21 May 2018

File No: 2018/270295
Ref No: R/2018/7
Your Ref: SSD 8636

SSD 8636 – Engineering And Technology Precinct, The University Of Sydney, Darlington Campus

The City has reviewed the information and provides the following comments:

Landscape Concept

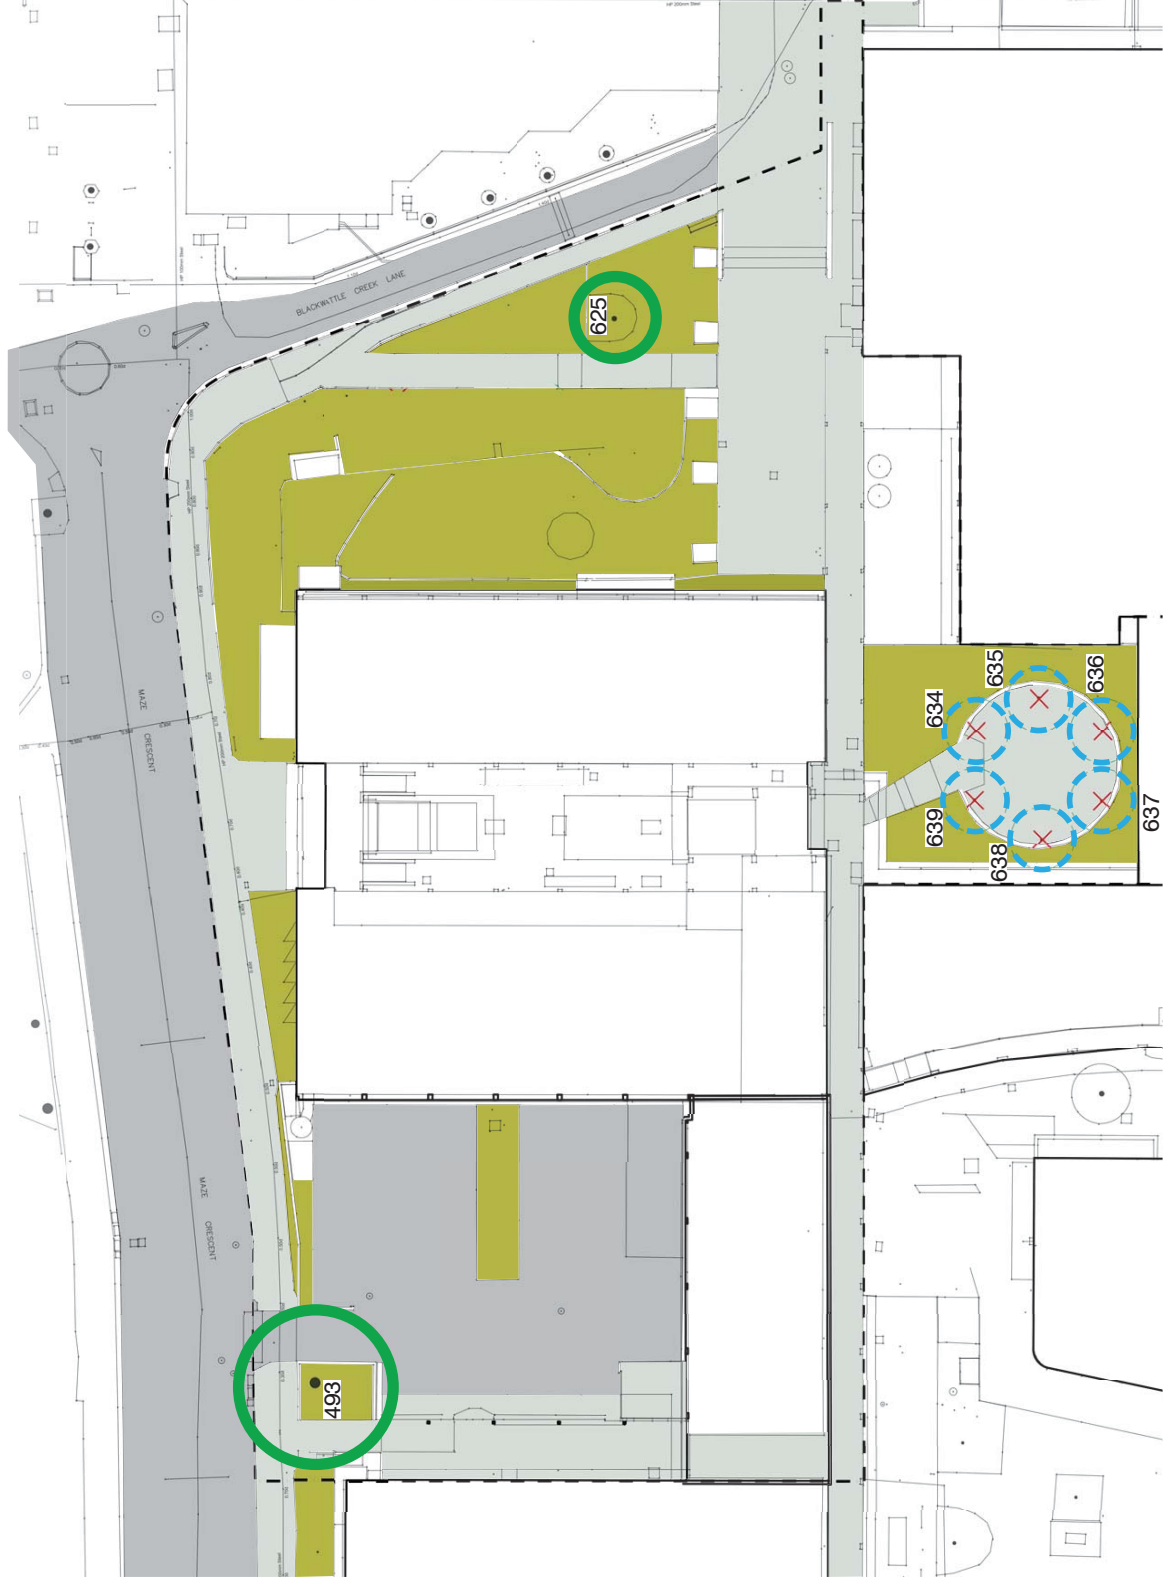
The landscape concept plan and sections are hand drawn and illustrative in nature. The information submitted does not provide a sufficient level of detail to understand the complexity of the public domain areas or offer assurance that necessary coordination between the architect, landscape architect, civil engineer and arborist has occurred. In order to make an informed assessment of the proposal, the Department are advised to request the proponent prepare a more detailed landscape package of information including:

- With reference to existing trees to be retained and trees located in raised planters, it is not clear what the height of planter walls is and whether there is adequate soil depth and volume to support the mature trees. The design must achieve a minimum 1000mm soil depth (excluding draining and mulch layers) for all trees on slab or podium;

- The focus of the design appears to be patterning the ground plane rather than resolving the detail and how changes in levels, stairs, ramps, and structures are dealt with in the public domain. These spaces need to be appropriately illuminated.

- It is not clear if permeable pavement is proposed, which would help mitigate overland flow issues and increase areas of deep soil provision on the site;

- There is no clear indication of what furniture and fixtures including lighting, water features, seating, benches, tables, bins, bike racks etc. are to be provided within the landscaped public domain areas, and any impact they may have on accessibility;

- Methods of irrigation and drainage are not clear from the package; and
- The drawn information shows the building per level. There is no overall site plan that shows thresholds and entrances relative to the public domain. Updated sections should be provided that show existing and proposed ground levels.
